**RESPONSE TO SUBMISSIONS  
NORTH EAST PLOT (SSD 6626 MOD 1)**

This letter, prepared by JBA on behalf of the proponent, sets out the responses to the issues raised on the modification application to the North East Plot Development Consent (SSD 6626) in accordance with Clause 85A of the *Environmental Planning and Assessment Regulation 2000* (EP&A Reg).

FLOOR PLAN LEVEL 08 -18

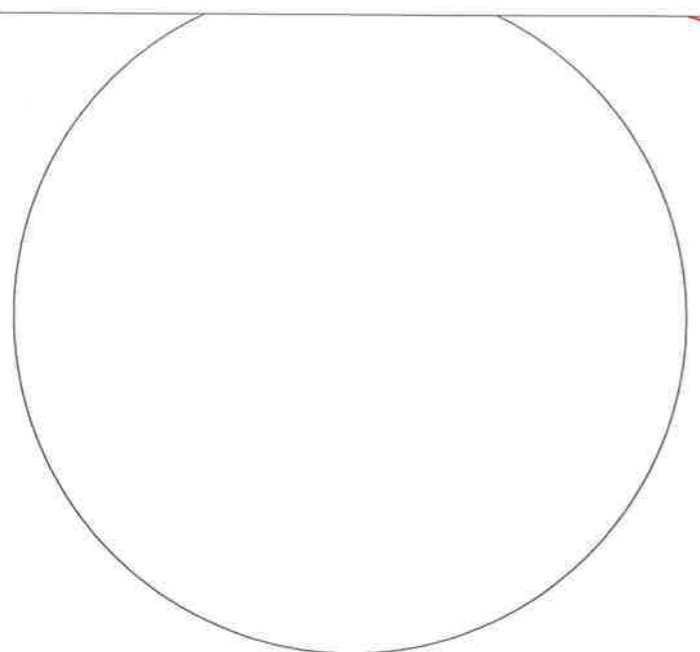
The Department has also requested further justification on the following items:

- relocation of the western façade of Building NE3 in the context of residential amenity; and
- relocated fire tank in relation to its size and access arrangements, having regard to relevant standards.

The proposal includes 33 apartments with a living room width 300mm below the recommended width in the design criteria for Objective 4D-3 (3.7m opposed to 4m), and 33 apartments with balconies 1m<sup>2</sup> below their original approved size (total 7.7m<sup>2</sup>).

Both the living rooms and balconies remain usable spaces where a range of furniture layouts are capable of being accommodated. The spaces are well proportioned and efficiently organised within the apartments, creating a clear hierarchy of spaces and catering to a variety of living requirements. **Figure 2** illustrates the proposed apartments and identifies the location of the living room and balconies requiring further detailed assessment.

Figure 2 – Level 8-18 floor plan extract (subject living room outlined in blue / subject balcony outlined in red)

Approved SSDA7 Floor Plan - Typical

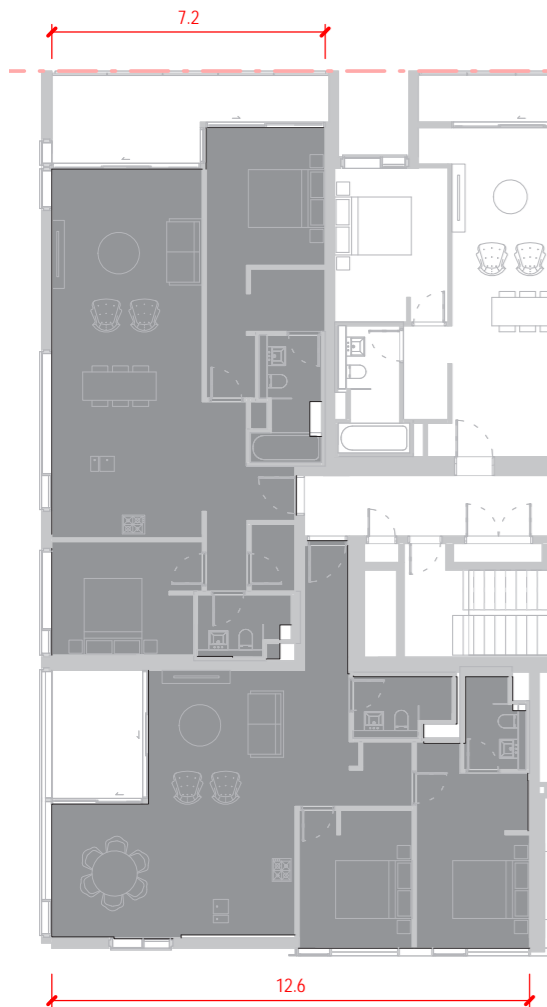
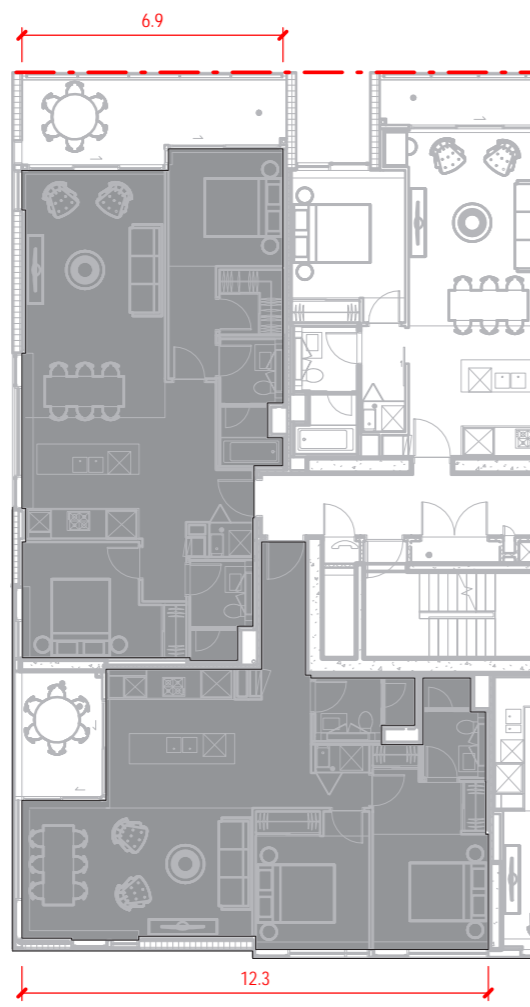
It is clarified that the western façade of Building NE3 has shifted 330mm to the east. The Department has requested further justification of this amendment. It is clarified that this amendment has been driven by a number of matters, including general design development and importantly as a response to in-ground site conditions which were not precisely defined at the time the original development consent was granted.

An existing foundation associated with the SEC was identified below the location of the previous western wall of Building NE3. In order to avoid significant in-ground works to remove this foundation, the wall has been shifted 330mm to the east. The relationship of Building NE3 and the foundation is illustrated in Figure 1 below.
